Submission Form

Epping to Thornleigh Third Track Proposal. Application number SSI 5132.

Name(s): Neil David Tribe and Catherine Faye Tribe

Figure S.6 Cross-section and elevation - New Cheltenham Station concourse building (see also S.5 for artist's impression)

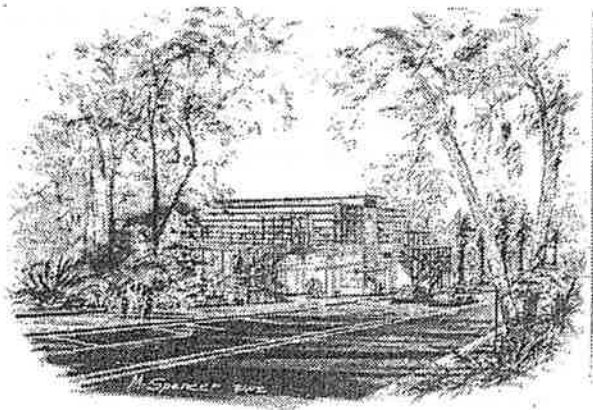
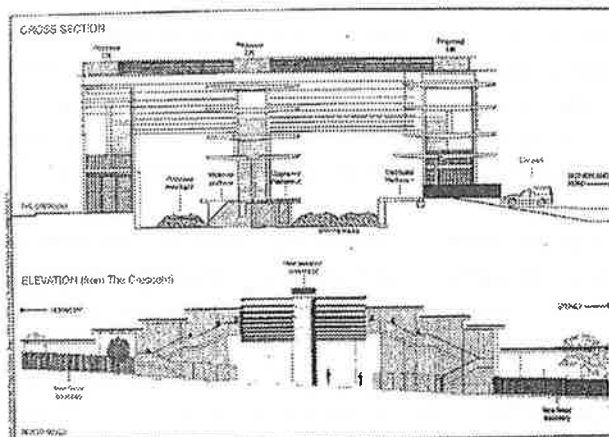
- The proposed redevelopment of Cheltenham Station shows no regard for the HCA. The visual impact of the proposed 13m high glass and steel concourse is totally unacceptable in this HCA.
